**Date:** 12 October 2021

**Planning Act 2008 – Section 88 and the Infrastructure Planning (Examination Procedure) Rules 2010 – Deadline 10: Comments on 3.1(I) Draft DCO Tracked Changes Version- Revision 10 against Revision 9**

**Application by NNB Generation Company (SZC) Limited for an Order Granting Development Consent for the Sizewell C Project**

DRAWING NO: SZC-SZ0100-XX-000-DRW-100205	REVISION: 02
DATE: JULY 2021	DRAWN: CGK
	SCALE: AS SHOWN @ A1

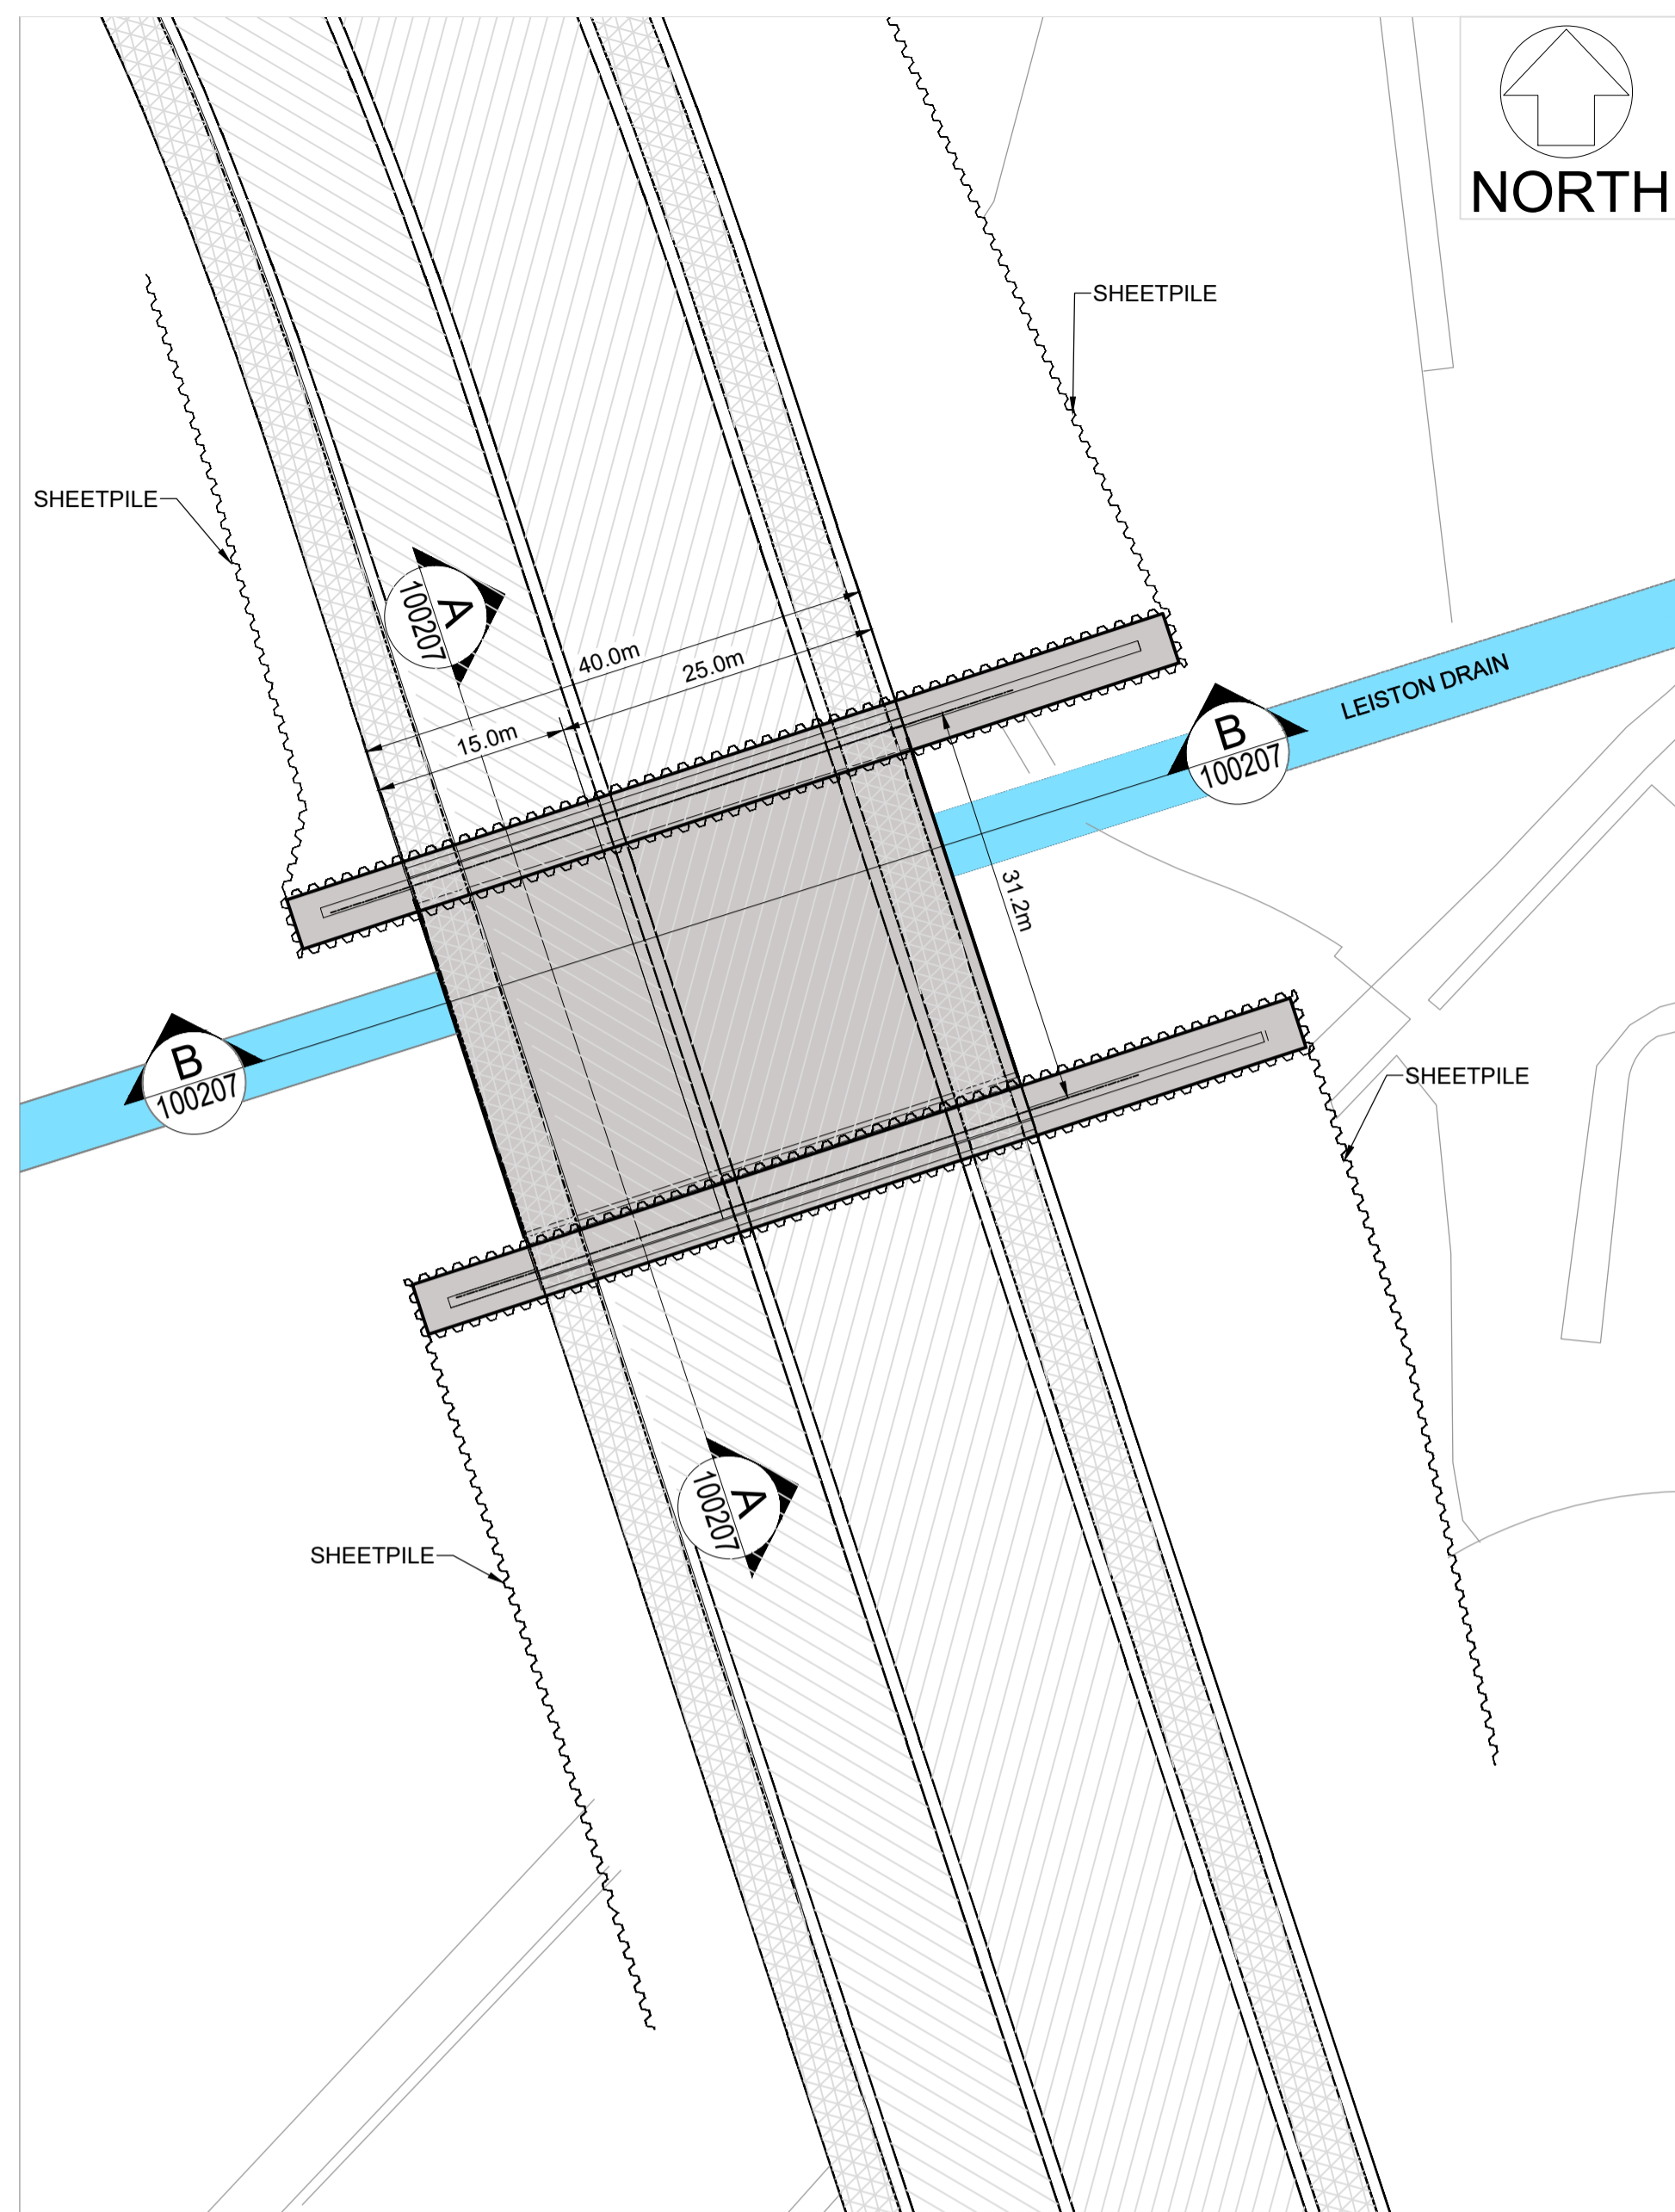
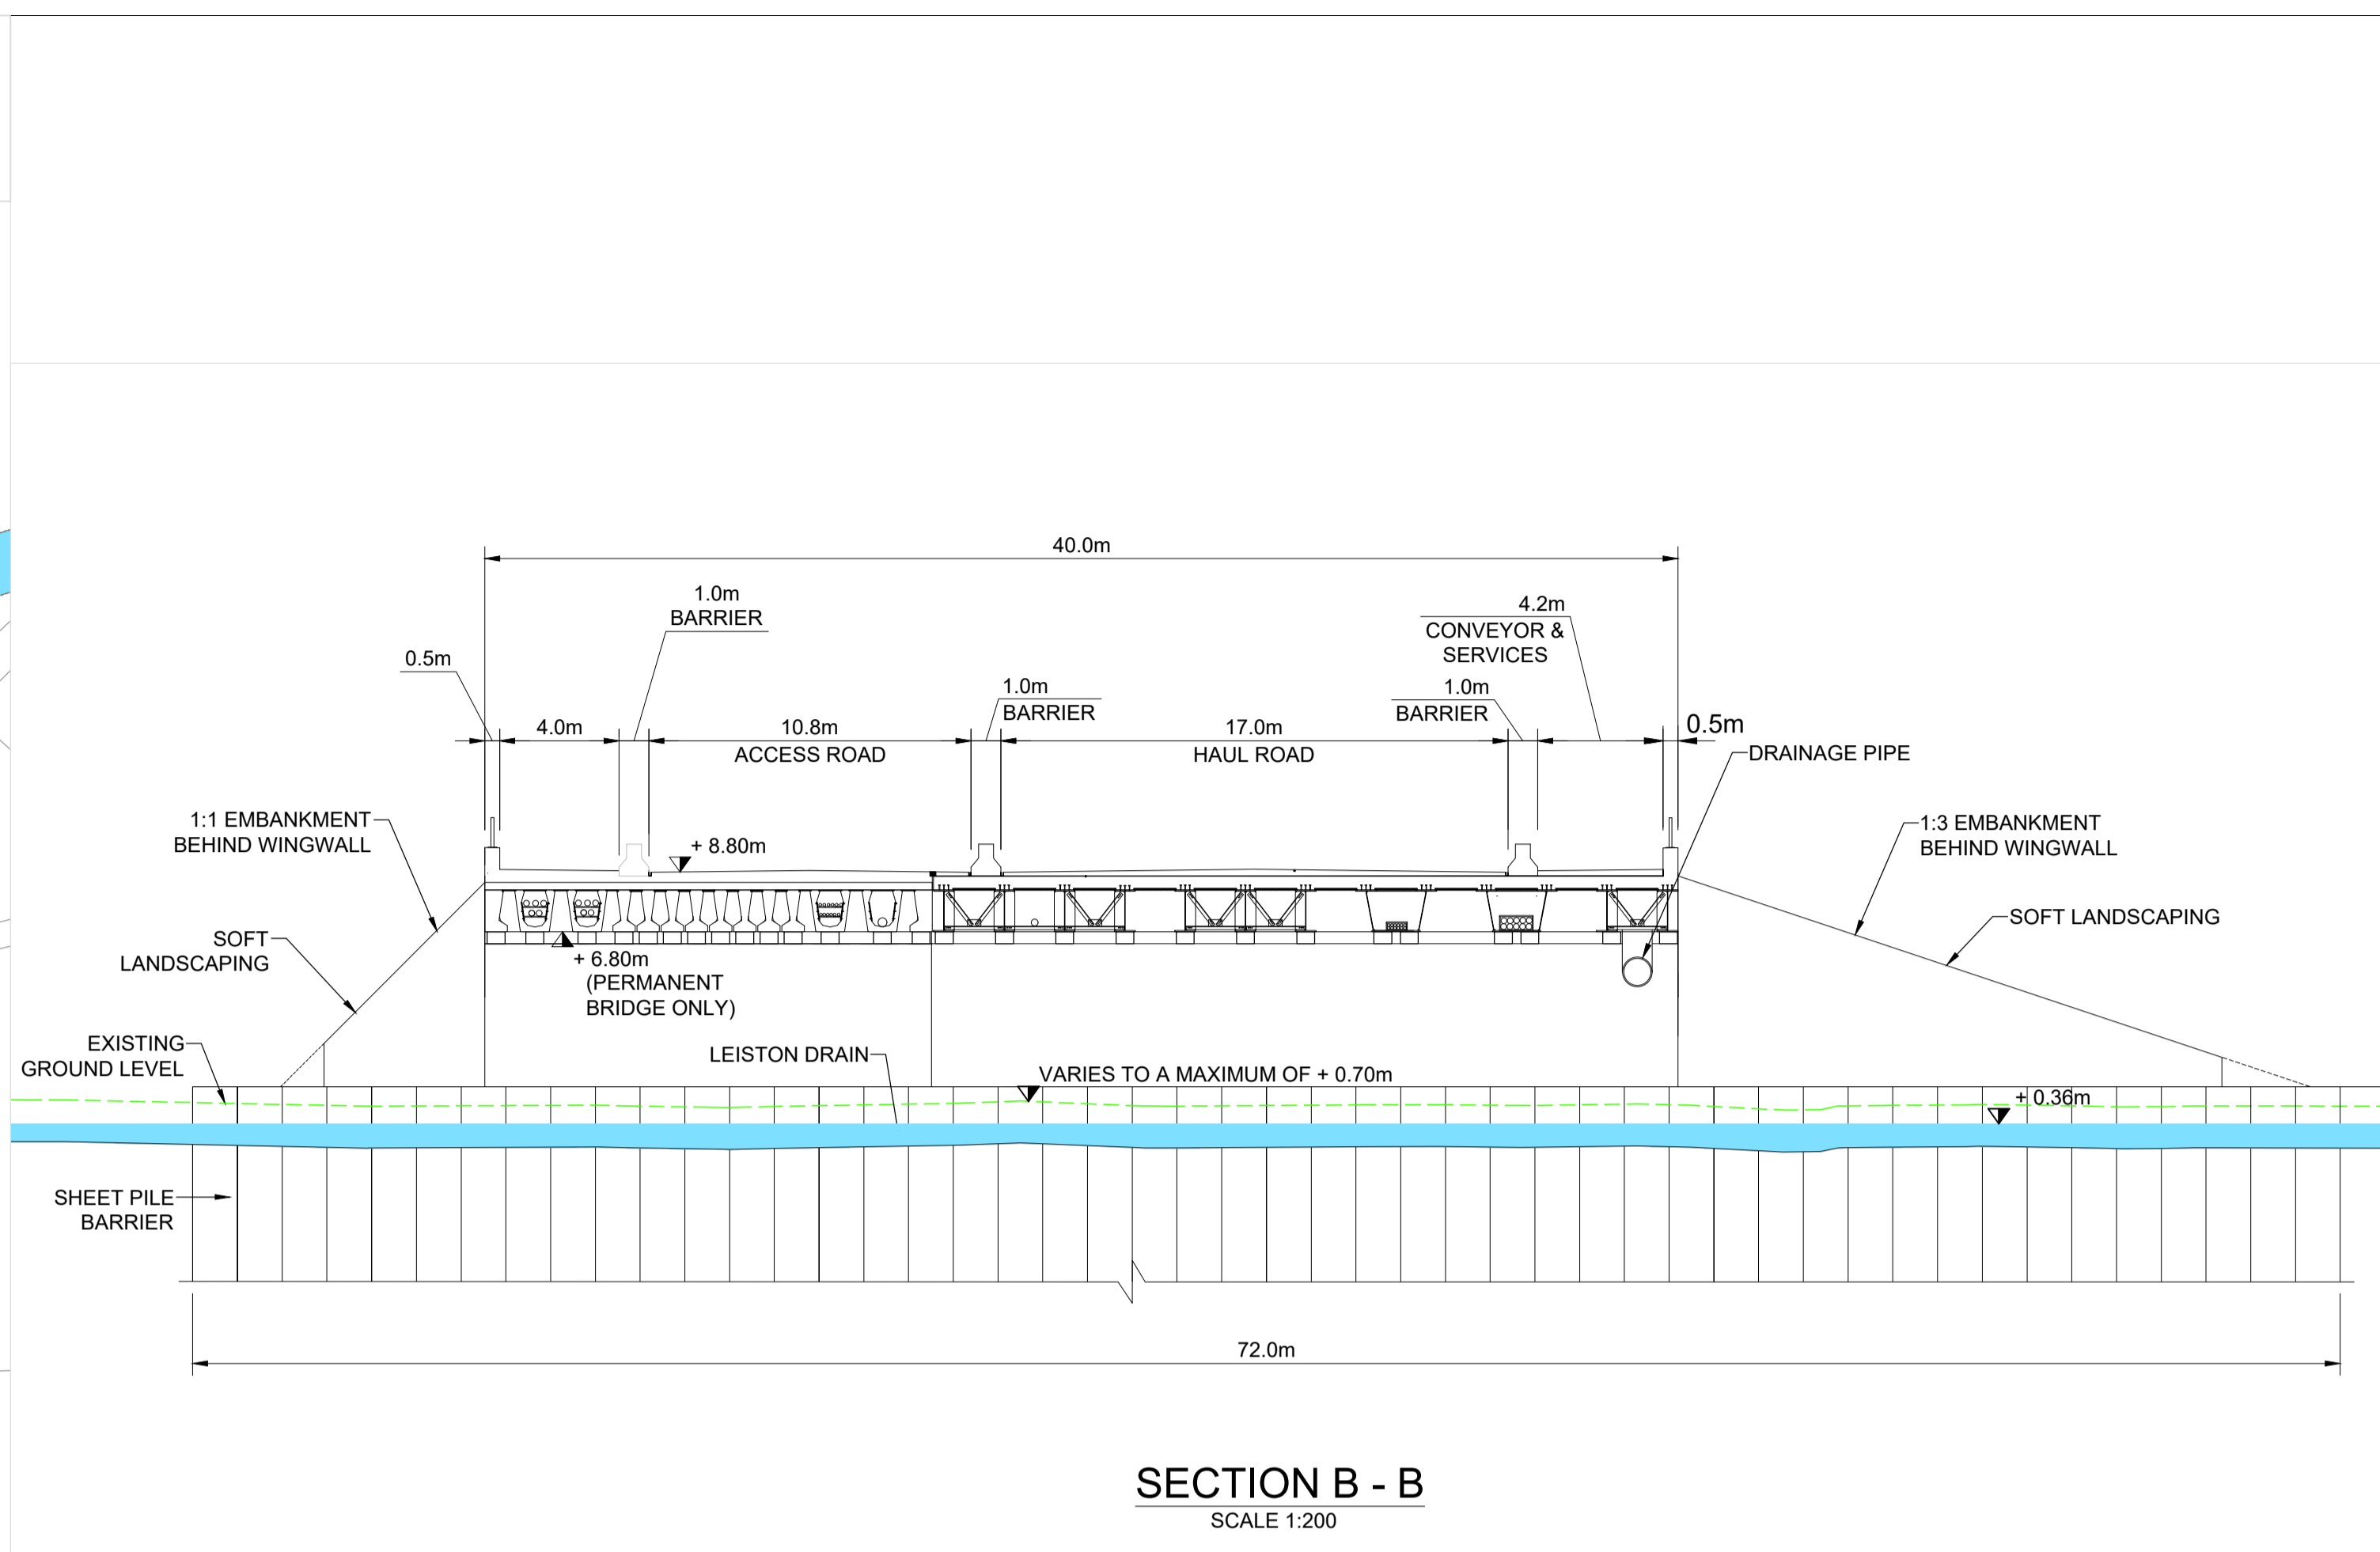
Section	Wording	Comments
<b>Schedule 2, Article 3 - Requirements</b>		
<p>Requirement 12C,</p> <p>Main development site: SSSI Crossing</p>	<p><b>Main development site: SSSI Crossing</b></p> <p>(1) Unless otherwise approved by East Suffolk Council, the temporary SSSI Crossing must be built in general accordance with Chapter 5 of the Design and Access Statement and in accordance with the following details:</p> <p>(a) Main Development Site SSSI Crossing (SZC Construction) (July 2021) (Drawing Ref: SZC-SZ0100-XX-000-DRW-100207);</p> <p>(b) Main Development Site SSSI Crossing (Bailey Bridge Stage) (July 2021) (Drawing Ref: SZC-SZ0100-XX-000-DRW-100209).</p> <p>(2) Construction of the permanent element of Work No. 1A(I) (SSSI Crossing) must not commence until details of the layout, scale and external appearance have been submitted to and approved by East Suffolk Council, following consultation with the Environment Agency and Natural England. The details must:</p> <p>(a) be in general accordance with the Main Development Site SSSI Crossing (SZC Operational) (July 2021) (Drawing Ref: SZC-SZ0100-XX-000-DRW-100205);</p> <p>(b) include layout and scale which has:</p>	<p>We welcome the inclusion of the new Requirement 12D that will make the Environment Agency a consultee in discharging the method statements for the SSSI crossing construction.</p> <p>We consider however, that the potential environmental impacts, including Water Framework Directive concerns, relate to both the construction and permanent elements of the SSSI Crossing.</p> <p>On this basis, we consider that the Environment Agency should be proposed as a consultee in discharging (1) Construction works – should there need to be any change to the design of the construction works.</p>

<p>(i) a crest no lower than 8.6m (AOD);</p> <p>(ii) a soffit no lower than 6.8m (AOD) at its intersection with the Leiston Drain; and</p> <p>(iii) a span no wider than 15m.</p> <p>(c) include a flood risk monitoring and adaptive defence plan that sets out the periodic monitoring proposals for the SSSI Crossing and the trigger point for when the crest height of the SSSI Crossing would need to be increased to 10.5m (AOD).</p> <p>(d) a timetable for the works, including a timetable for the return of temporary SSSI land.</p> <p>(3) Work No. 1A(l) (SSSI Crossing) must be carried out in accordance with the approved details.</p>	
<b>Schedule 20 — Deemed Marine Licence under Part 4 (Marine Licensing) of the Marine and Coastal Access Act 2009</b>		
<p>Condition 17: Coastal Processes Mitigation and Management Plan</p>	<p>17.—(1) The construction of Work No. 1A(n) must not commence until a CPMMP has been submitted to and approved by the MMO in writing. The CPMMP must be in general accordance with the Draft Coastal Processes Monitoring and Mitigation Plan and must include—</p> <p>(a) Details of the area to be monitored;</p> <p>(b) the methods for monitoring;</p> <p>(c) the duration of monitoring;</p> <p>(d) the trigger points for mitigation;</p> <p>(e) a description of any proposed mitigation;</p> <p>(f) examples of mitigation measures which could be implemented and which would be effective to mitigate particular results of the monitoring and how the appropriateness of each measure will be considered;</p> <p>(g) details concerning the appropriate timing for a monitoring and mitigation cessation report to be prepared.</p> <p>(2) The CPMMP must be implemented as approved by the MMO.</p>	<p>The proposed condition now removes the Environment Agency as a consultee for the CPMMP. We request that the condition is amended to include the Environment Agency as consultee of the detailed information.</p>
